**KIRKLEES METROPOLITAN COUNCIL  
INVESTMENT & REGENERATION SERVICE**

**DELEGATED DECISION TO DETERMINE PLANNING APPLICATIONS**

Reference No:	<b>2023/62/93295/W</b>
Site Address:	adj, 1, Oastler Avenue, Springwood, Huddersfield, HD1 4EU
Description:	Erection of detached dwelling
Recommending Officer:	William Simcock

## **Officer Report – 2023/93295**

**1 Rear Elevation**  
1 : 100

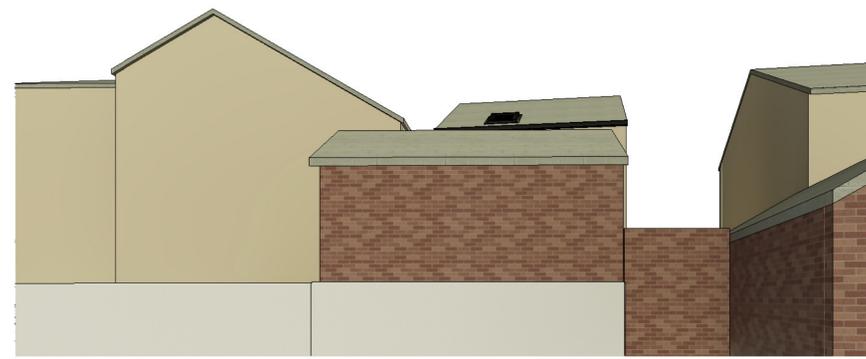
The earlier version of the plans for this application showed the dwelling being three-storey at the rear. Since it would be located within an area strongly dominated by two-storey development and would be possible to see it from the gap 48 and 50 Springwood Avenue, where a three-storey elevation would be seen to stand out noticeably from its surroundings, this was judged unacceptable. The plans have been modified so that the front wall and rear wall would be of the same height. The proportions of the house would still be different to surrounding development in that the distance between the top of the lintel to the first-floor front window and the eaves line would be up to 400mm, whereas for 33 Lynton Avenue it is approximately 150mm (the thickness of one course of stone). The main first-floor window in 1 Oastler Avenue facing on to Linton Avenue has no space between lintel and eaves, contrary to what the street-scene elevation shows. In the case of the rear elevation, the gap between the first-floor lintel and the eaves would be greater but it would also be less visually prominent. It is considered on balance however that the positioning of windows relative to eaves would not give rise to a strongly non-conforming appearance within the townscape, as overall wall height and most other design details would strongly resemble its surroundings.

The elevations confirm that the first and second-floor rear-facing windows would be obscurely-glazed. These comprise a bathroom, landings and a secondary window to bedroom 3. To ensure that the privacy of other residents is not compromised, it should be conditioned that these windows are fitted with obscure glazing and be non-opening or top-opening, and to be so retained thereafter. This condition does not need to apply to the rooflight to Bedroom 3 since it would be more than 1.68m above internal floor level and would therefore not allow a view out over other residential properties. There are no windows in the side elevations. As a precautionary measure it is recommended it be conditioned that no windows are formed in the side elevations at ground level unless they have a sill at least 1.7m above floor level.

**6 Front Elevation**  
1 : 100

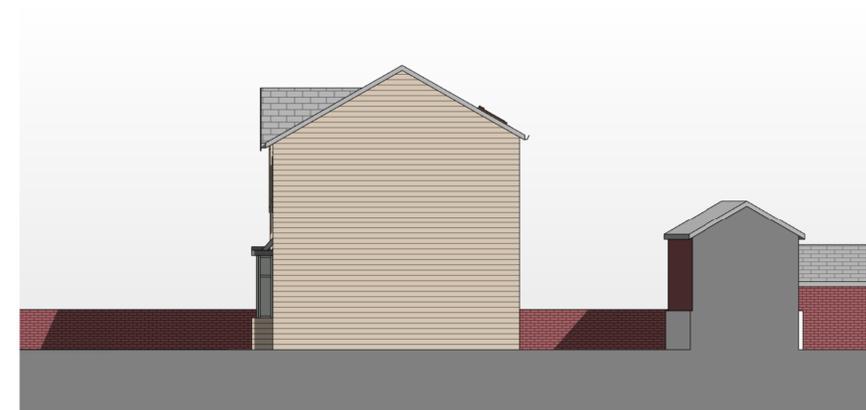
The proposed dwelling would have an eaves and ridge height similar to that of the neighbouring dwelling, no. 33, and its principal outer front wall would be set only marginally in front of the line formed by the main front wall of nos. 31-33, its front bay marginally behind. It would be placed so that the gap between its own western wall and the eastern wall of no. 1 Oastler Avenue would be 4m at the front and 1m at the rear, owing to the eastern elevation being stepped. In the other direction, the gap between the eastern side wall and the opposing wall of no., 33 would also be 4m. Gaps between facing side elevations on Lynton Avenue vary between 4.2m and 5.4m. It is therefore considered that the placement of the dwelling within the plot, its relationship to the side boundaries and to the building line formed by 31-33 Lynton Avenue, would not give rise to a non-conforming feature within the street scene.

The roof is asymmetrical, in the sense that the ridge would be placed closer to the rear than the front wall. The pitch of the front and rear roof slopes would be the same, however.
